Recommendation Report for Planning Permission for Works or Extension to a Dwelling

REF NO: FP/254/18/HH

LOCATION: 3 The Grove
Felpham
PO22 7EY

PROPOSAL: Single storey rear extension and internal alterations

DRAWING
PROPOSED PLANS
DRAWING No
266/04
SCALE
1:100
DATE
11 MAY 2018
REVISION
DRAWN
CHECKED
LA

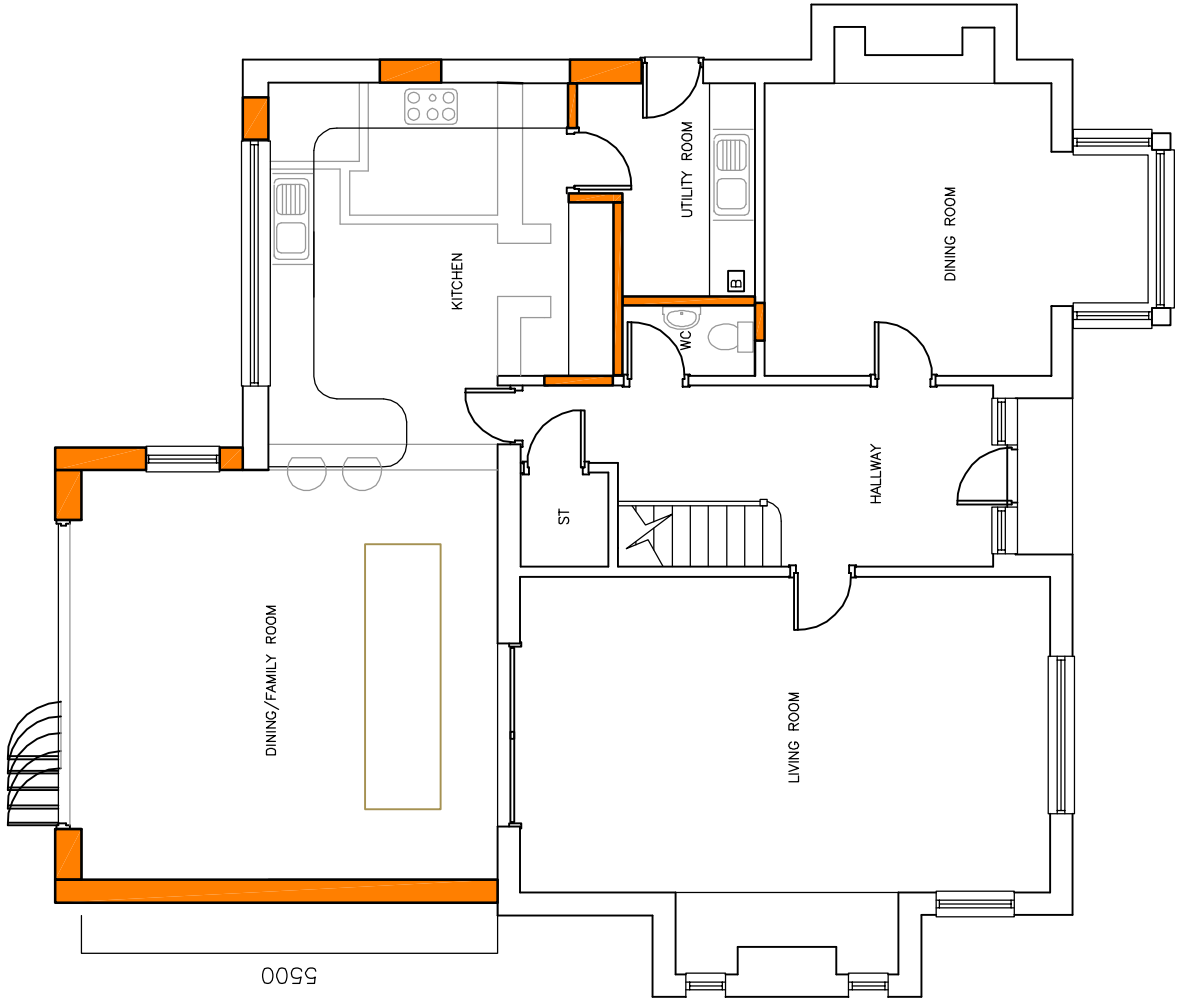
The dwelling has an existing conservatory however this will be replaced with a rear extension. The extension will have a depth of 5.5m and extend beyond the existing rear wall of the dwelling by approximately 2.5m. It will be constructed with a slight lean to roof with a maximum height of 3.2 reducing to 2.9m.

**PROPOSED
ELEVATIONS**

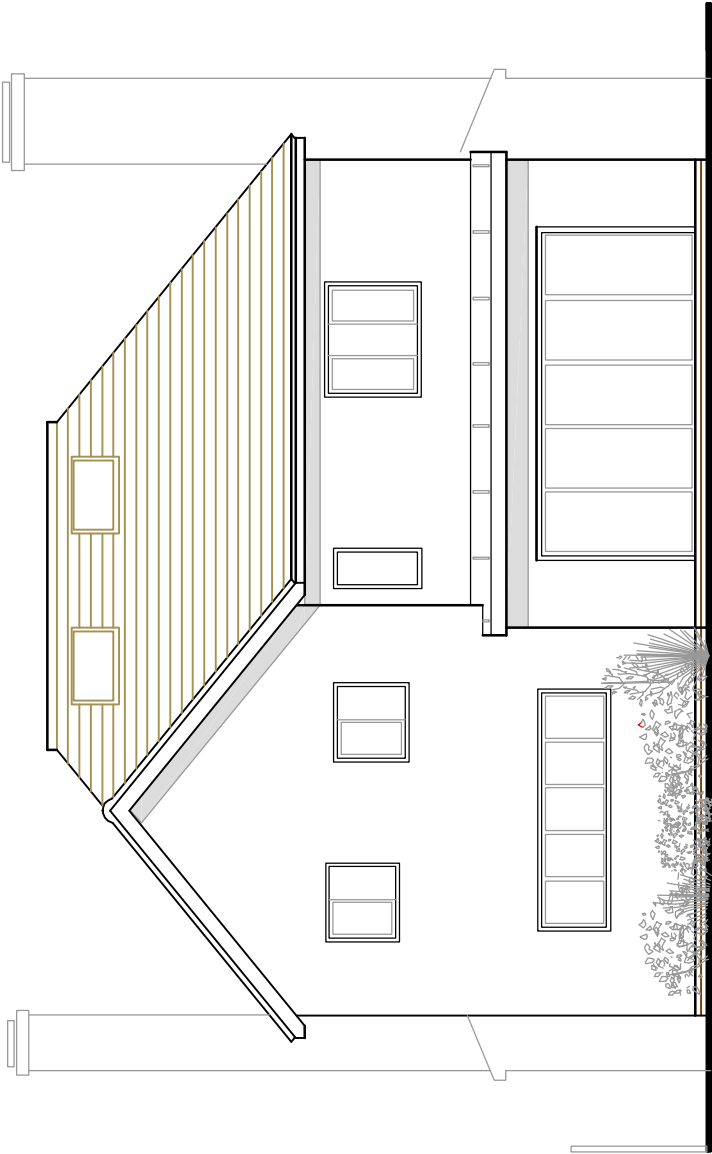
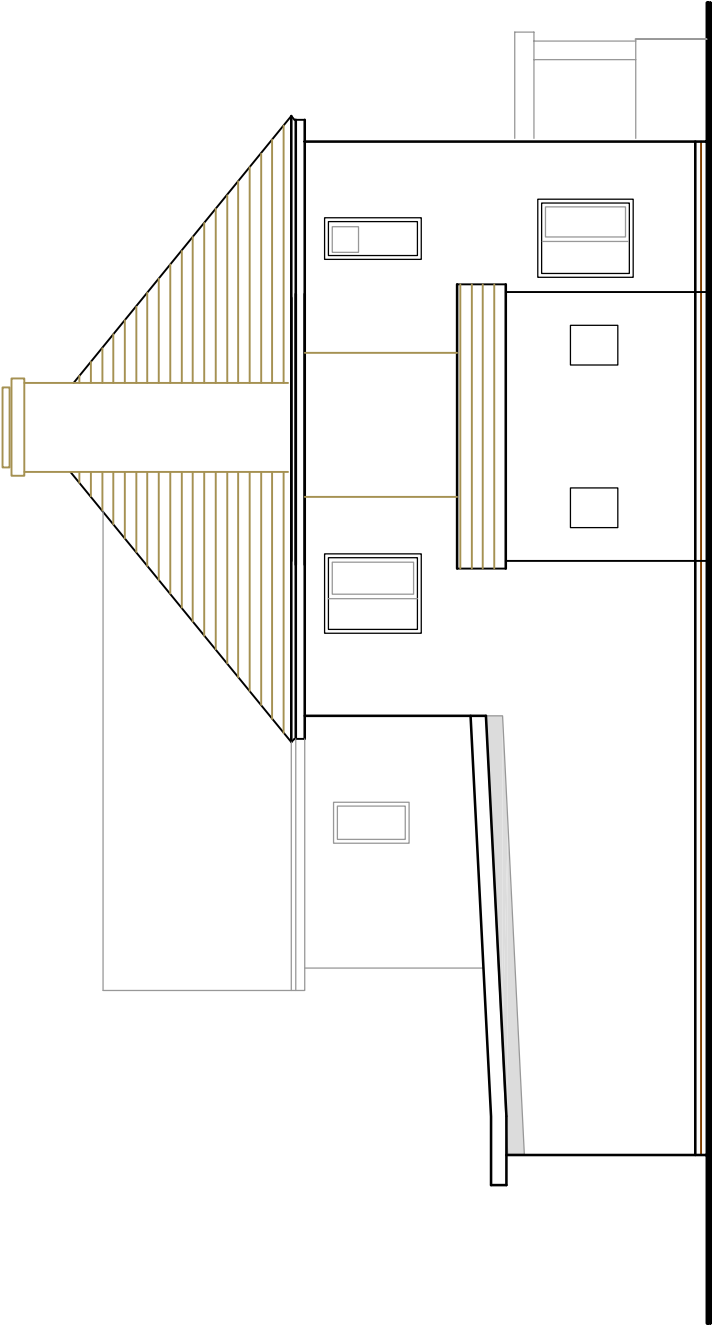
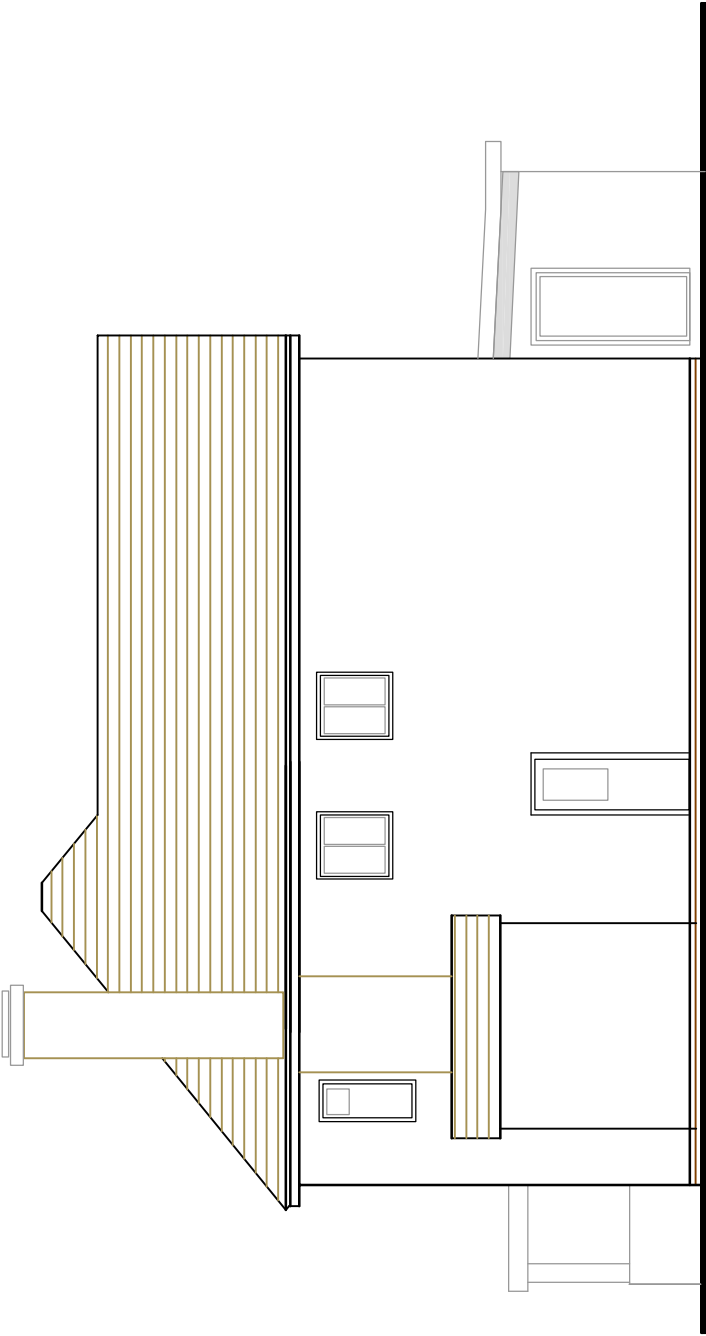
There is 3m retained to the western boundary and there are no windows proposed at this elevation. 1 door is proposed to the eastern elevation however due to the siting of the extension there is 6.5m to the boundary fence line and with the development at single storey it is not considered to give rise to any adverse overshadowing or overlooking upon this elevation. Doors to the rear elevation of the extension will overlook the garden and with 26m to the rear boundary there is not considered to be any adverse impacts as a result of this.
